Application Number SSI 7485

WestConnex M4-M5 Link – Modification 2 The Crescent overpass

Geoff Klimpsch  
Leichhardt

Figure 4-4 Elevation: Indicative view of The Crescent overpass

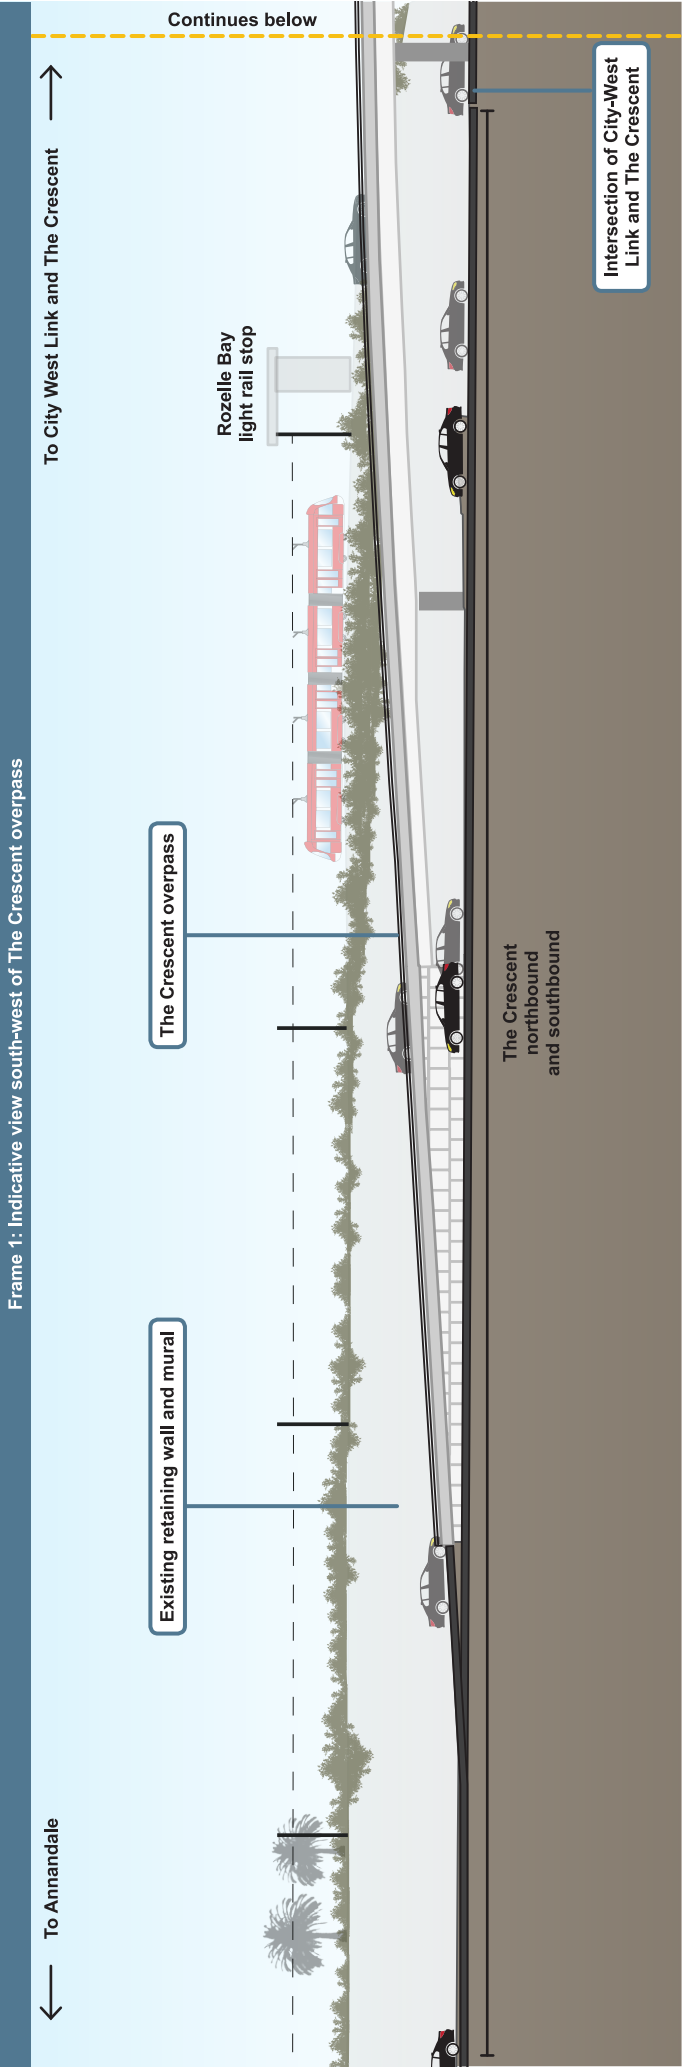
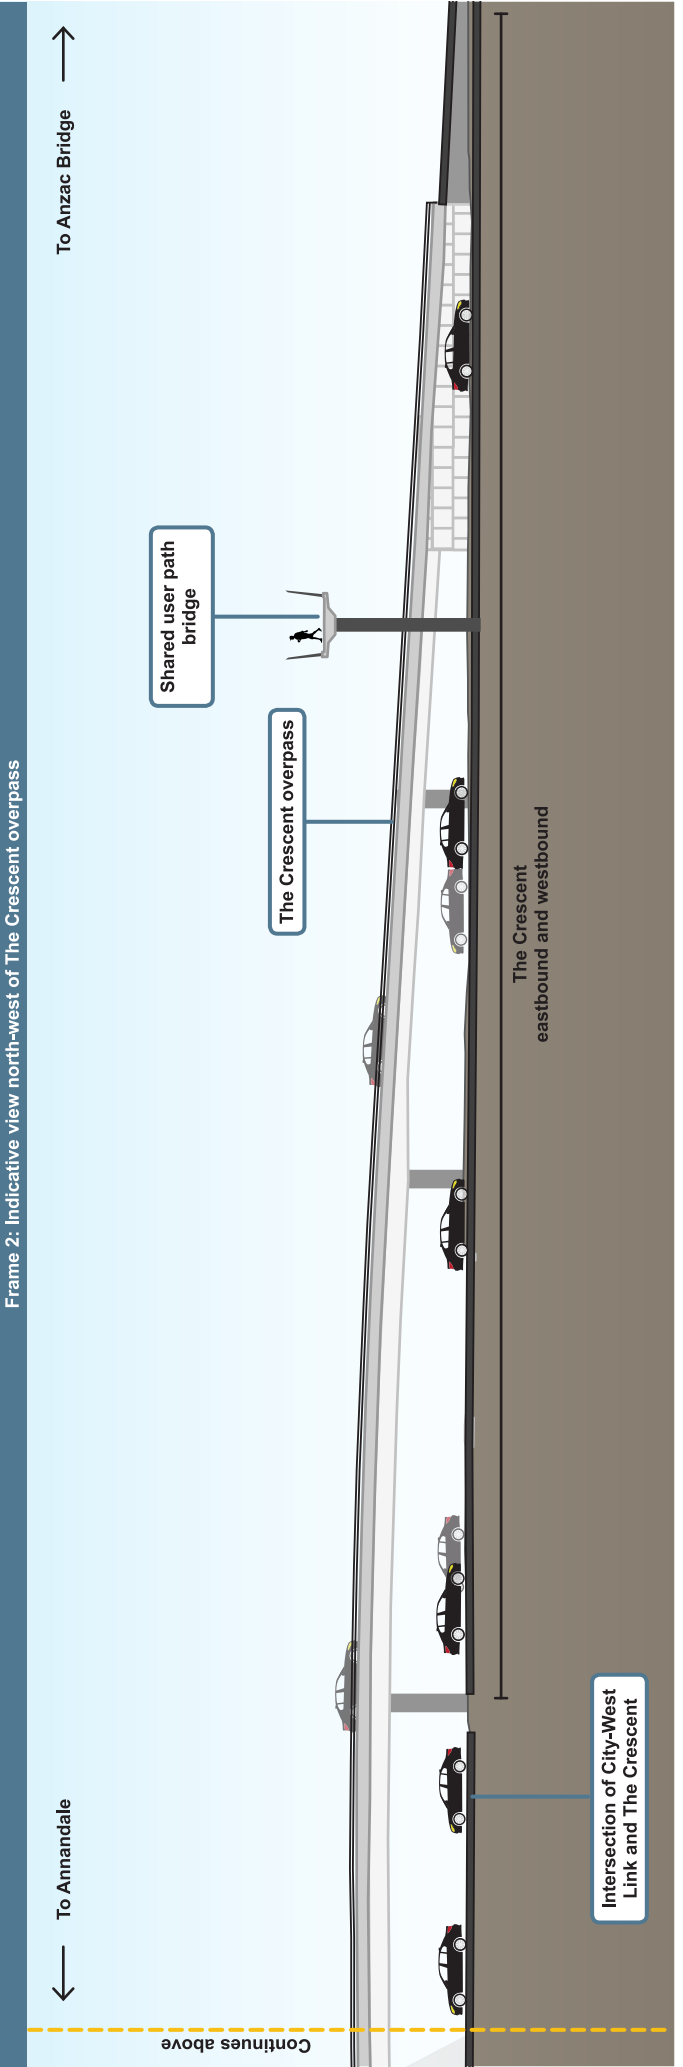
The planning, with a visually aggressive outcome by way of the excessively high and convoluted pedestrian overpass, will forever be seen as the compromise that it is. This apparent eyesore could be avoided by dropping "The Crescent overpass" to below the existing City West Link, and thus allow the "Shared user path bridge to be lowered some 5 meters (see page 58, Figure 4-7 Elevation: Indicative view of the shared user path bridge).

Is this engineering for engineering sake, or a constructors cost saving measure? Further, from past experience of 'photomontages used to sell projects', as this is, a comparable photo taken of the completed project, 'will be highly likely' to demonstrate an 'as-built' that is far more intrusive, brutal and inelegant than 'architectural renders' photomontage' on page 140, Plate 6-8 Photomontage 5: Indicative view west from the corner of The Crescent and James Craig Road (**with project**).
